1. SUBMISSIONS SUMMARY MATRIX

2. LOCAL GOVERNMENT SUBMISSION

2.1 PENRITH CITY COUNCIL

Figure 2-4 – Proposed Development Layout

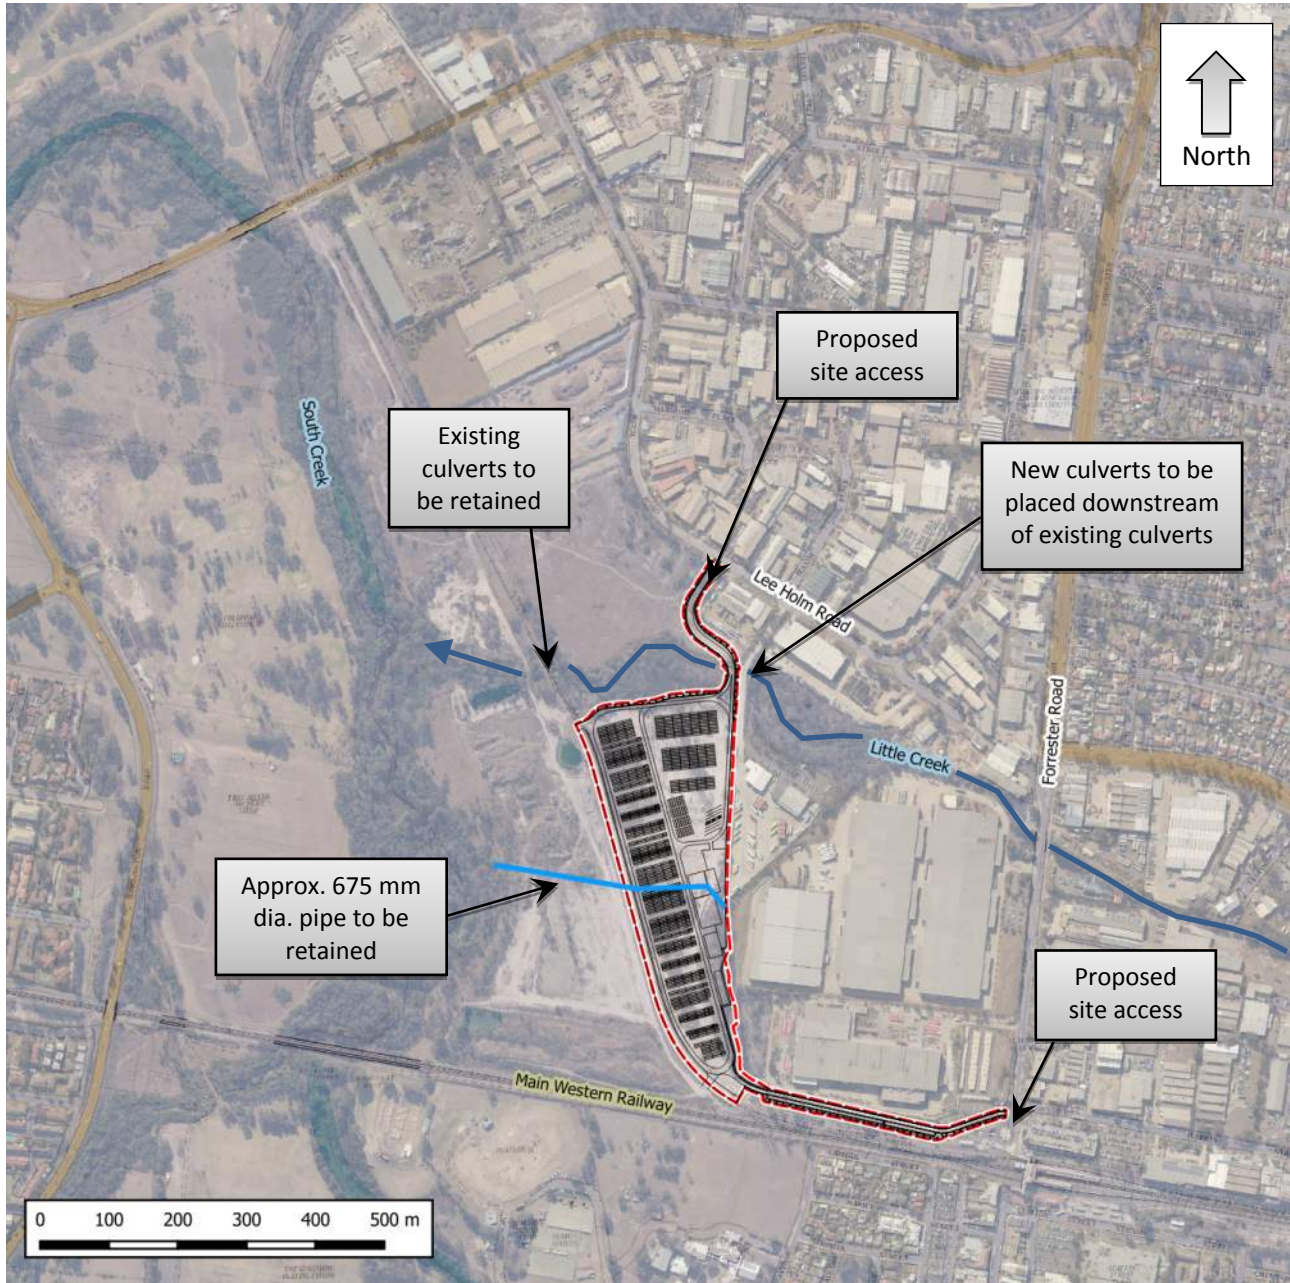
4	The proposed access via Lee Holm Drive is not acceptable because Lee Holm Road has a narrow roadway with multiple fronting driveways and land use activities. In addition, the B-double turn paths shown in Figure 7.4 of the TTA at the Lee Holm Drive access driveway use the full road width and full driveway width which is also not acceptable. Two-way truck use and car use at the Lee Holm Drive driveway is not acceptable. There was no assessment of SIDRA/swept path for the Lee Holm Drive/Christie Street which the applicant intends to use for both heavy vehicles including 26m B-double truck access and likely car access.		
		5	The B-double turn paths shown in Figure 7.3 of the TTA at the Forrester Road access driveway use the full road width and full driveway width which is also not acceptable. Two-way truck use and car use at the Forrester Road driveway is not acceptable. This is compounded by the existing traffic movements at the southern end of Forrester Road, accessing the commuter car parks, 'Kiss and Ride' area and commuter pick up and drop off area from the Bus Stop.

6	In considering the above, Council considers that heavy vehicle traffic generated by this development should be directly connected to the arterial road network and that the arterial road network should be upgraded to accommodate the increased heavy vehicle traffic. Any connections to Christie Street should include upgrading of Christie Street and connections to Dunheved Road, future Werrington Arterial Stage 2 (to be reconstructed by RMS), Forrester Road with additional connections to the proposed Outer Sydney Orbital. Access via local residential streets is completely unacceptable and the application should be refused on these grounds.

<p>been relocated to provide direct access from Lee Holm Road and suitable pedestrian access to work and visitor areas away from internal truck movements.</p> <p>It should be noted that the Freight Hub will reduce the length of many truck trips that are currently accessing customers via Port Botany (1 truck from St Marys replaces 9 to 10 trucks from Port Botany). Assuming that St Marys represents the centre of the market which receives its containers from Port Botany, approximately 55km per one-way truck trip generated will be reduced on the broader network. With 436 truck trips per day (218 IN and 218 OUT), this equates to 23,980 truck-kms per day removed off the regional road network or 8,752,700 truck-kms per annum.</p> <p>From a local road perspective Option 4 also has the added benefit of reducing truck movements on the local road network by providing the shortest route to the regional road network and its customer destinations, which translates into a savings in truck movements of up to approximately 0.5 million truck-kms per annum within the local road network when compared to the other route options under consideration.</p> <p>The traffic assessment demonstrates that Option 4 will:</p> <ul style="list-style-type: none"><li>▪ Have no impact of the Level of Service for accessed intersections and only results in an increase by a maximum of 5% on the Degree of Saturation of the intersections analysed using SIDRA method.</li><li>▪ Based on the assumed traffic volume distribution, peak traffic volumes (for Option 4), based on 2019 traffic volumes, will only increase by:<ul style="list-style-type: none"><li>- 1.6% on Forrester Road for trucks heading north after the intersection of Glossop Street and Forrester Road;</li><li>- 1.3% on Glossop Street; and</li><li>- 9% increase on Forrester Road south of Glossop Street. This portion of Forrester currently carries only 176 vehicles per hour south bound in the AM peak and 281 per hour northbound in the PM peak despite the typical capacity of a single lane urban road being 1,200 vehicles per hour. As a consequence, the low volumes of traffic make any relatively small increase in truck movements appear more significant.</li></ul></li></ul> <p>It is noted that the resultant increase in traffic is well within the predicted capacity for this road estimated at 1,200 vpd.</p> <p>This route (Option 4) and resulting traffic distribution on the surrounding road network has the least operational and safety impacts on the network, only utilises roads approved for B Double use and provides the most efficient distribution of trucks to and from the area.</p> <p>Furthermore, the intersection analysis of the 13 key intersections identified in the SEARs and in the subsequent Post Exhibited Version (Appendix 4) has revealed that the additional trucks generated by the development have a negligible incremental impact on the performance of these intersections.</p> <p>There is no reasonable basis for the claim that the assessment will place undue pressure or unacceptable burden onto the local road network.</p>

Figure 5-1 – Section Through Site and Swale to 10 Forrester Road

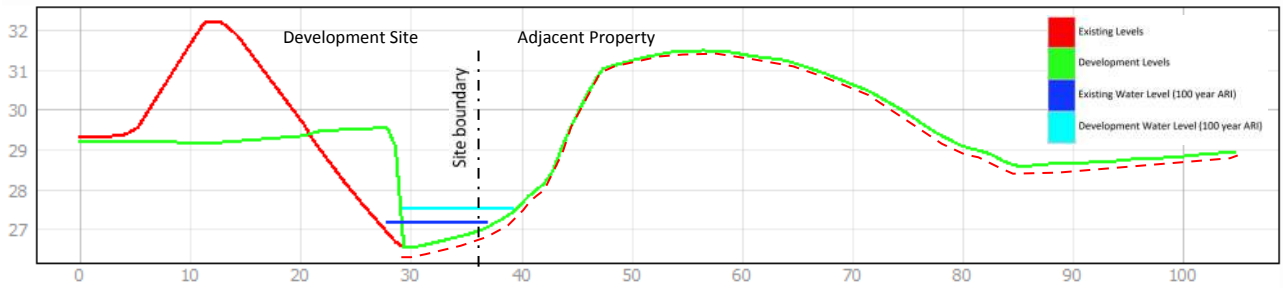
35	The development shall not have any adverse impact upon adjoining properties by the damming, concentration or diversion of existing stormwater flows	The development does not have any adverse impact on adjoining properties and meets the DCP afflux requirements.	
		36	As the development is predominately hard stand, post developed stormwater discharge flows are to match pre-developed flows
